**WELWYN HATFIELD BOROUGH COUNCIL
EXECUTIVE DIRECTOR - PLANNING, PUBLIC PROTECTION AND GOVERNANCE**

DELEGATED APPLICATION

Application No: 6/2020/1660/FULL
Location: 12 Harpsfield Broadway Hatfield AL10 9TF
Proposal: Erection of part four, part single storey rear extension and erection of a mansard roof extension to facilitate the creation of six new residential dwellings formed of 2 x studio and 4 x 2b4p units. Ground floor to be changed from a A3 restaurant to a A4 drink establishment, three vehicle parking spaces and cycle and refuse storage internally
Officer: Mr William Myers

Recommendation: Refused

DRAWING No.
PR-L001

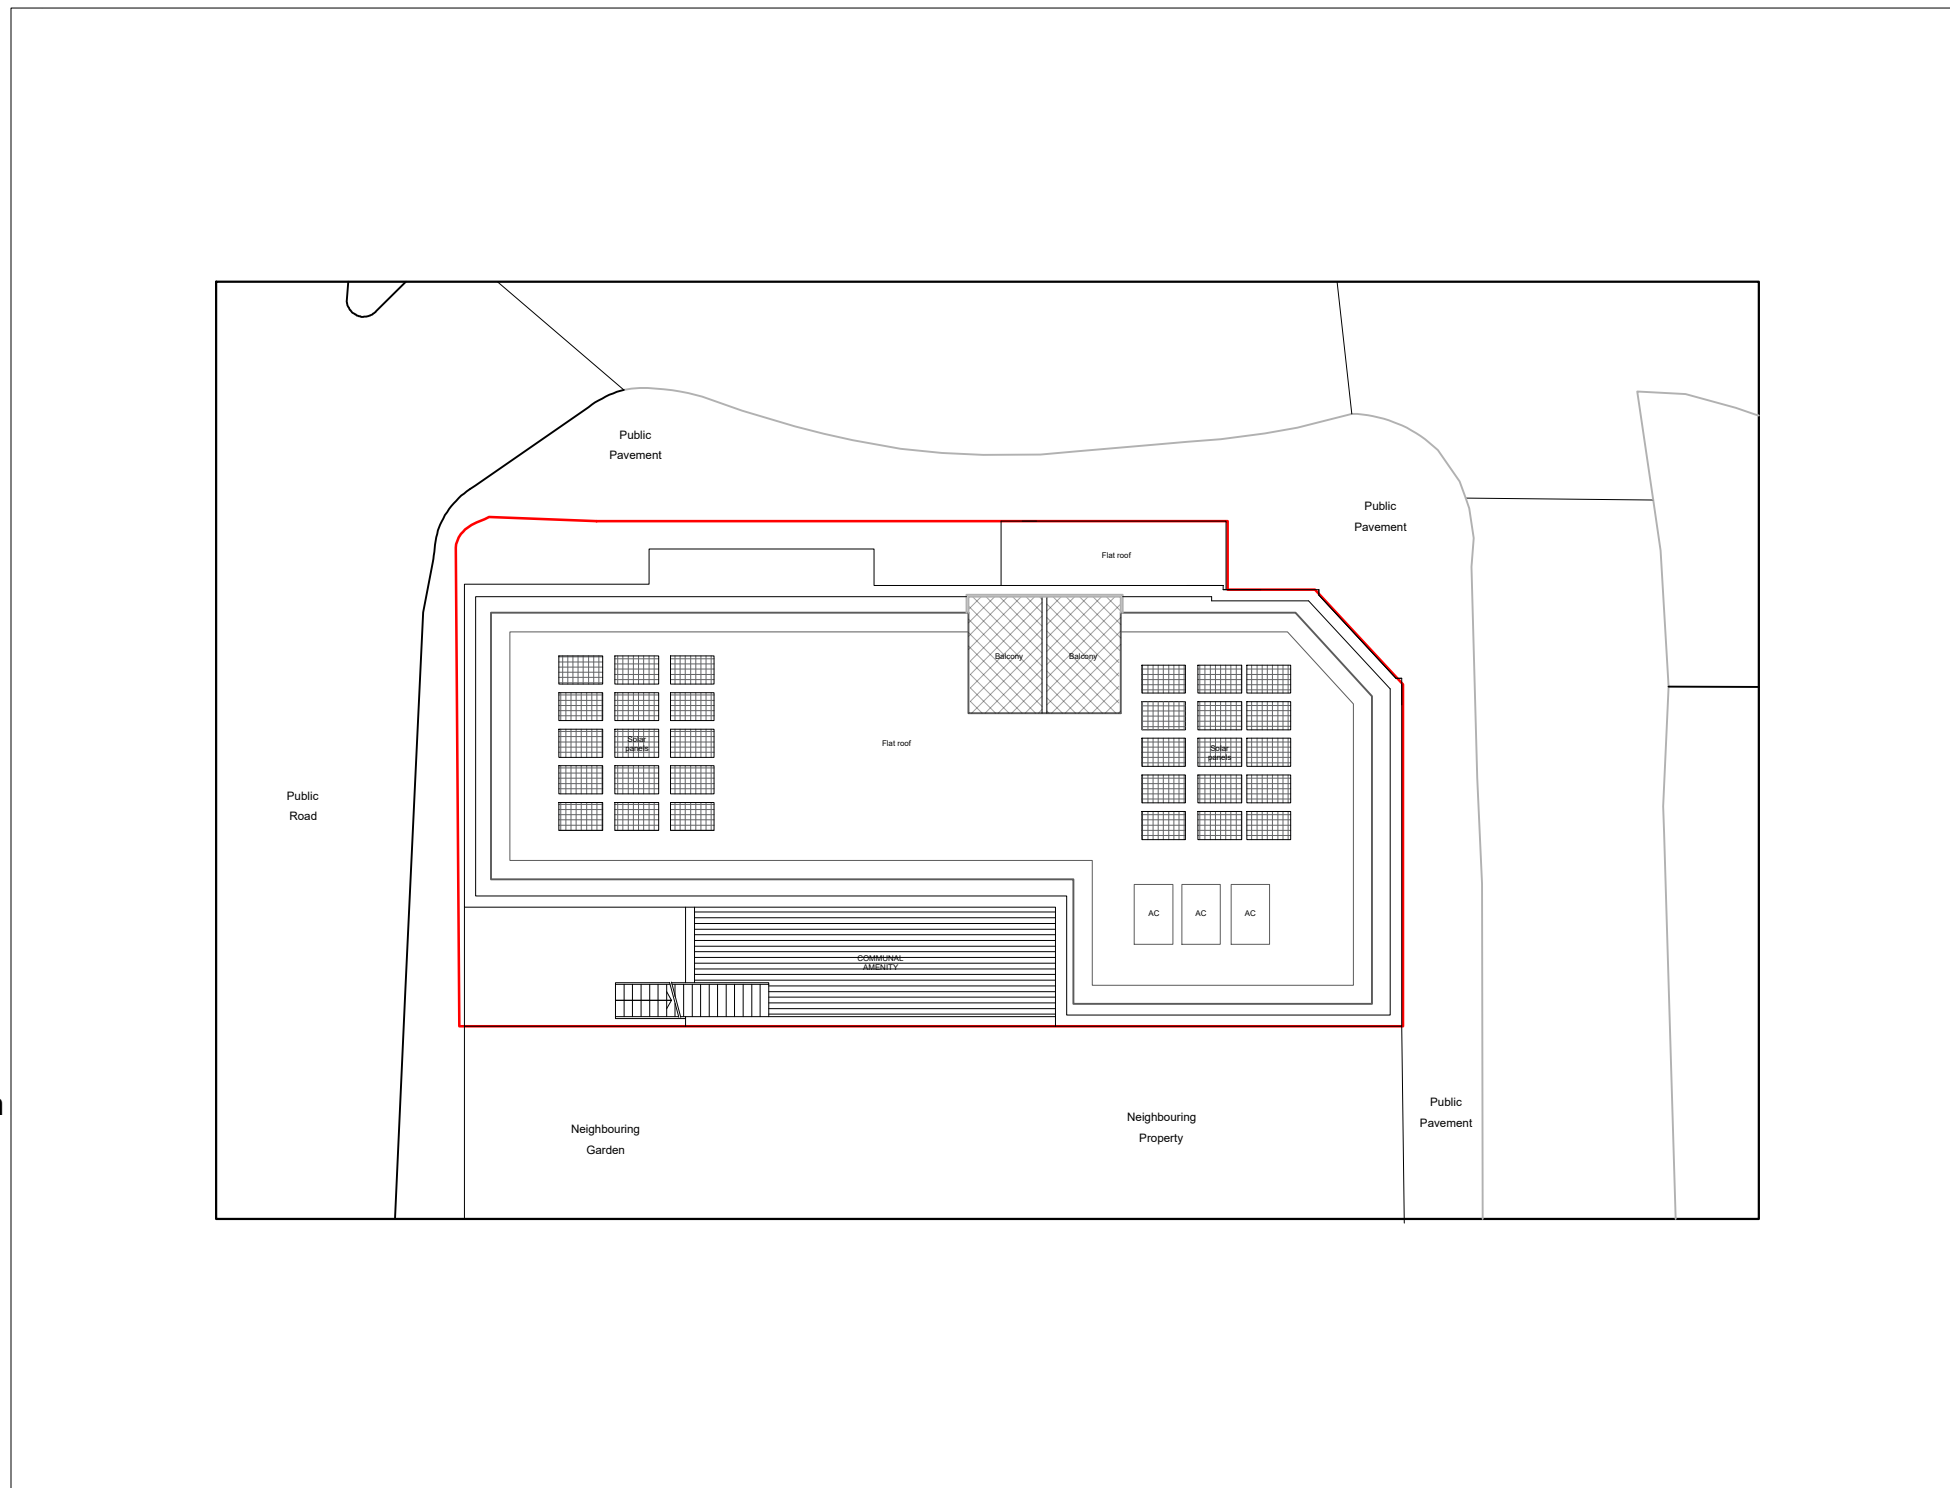
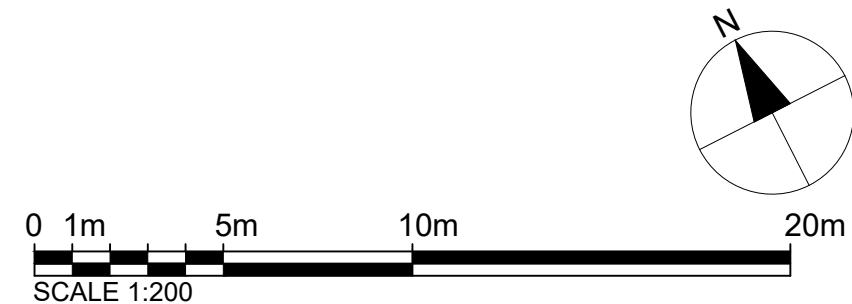
Further to the above, it is considered that the proposed access to the flats is unacceptable. The reason for this is because the only access to the flats is not served by a footpath but it would instead require future occupiers to walk on a road which forms part of the adjoining bus station. It is considered that such an access is unacceptable in both design and safety terms.

4. An inadequate level of car parking provision is provided for the proposed development which would further exacerbate the existing car parking pressures within the vicinity which would be harmful to the character of the area. In addition, the parking spaces which are proposed cannot lawfully be accessed because to do so would constitute a breach of the Highway Act. The proposal is therefore contrary to Policies M14, D1 and D2 of the Welwyn Hatfield District Plan 2005; Supplementary Planning Guidance Parking Standards 2004; Interim Policy for Car Parking Standards and Garage Sizes 2014; Criterion HMO2 of the Houses in Multiple Occupation Supplementary Planning Document 2012; Policy SADM12 of the Welwyn Hatfield Borough Council Draft Local Plan 2016; and the National Planning Policy Framework.
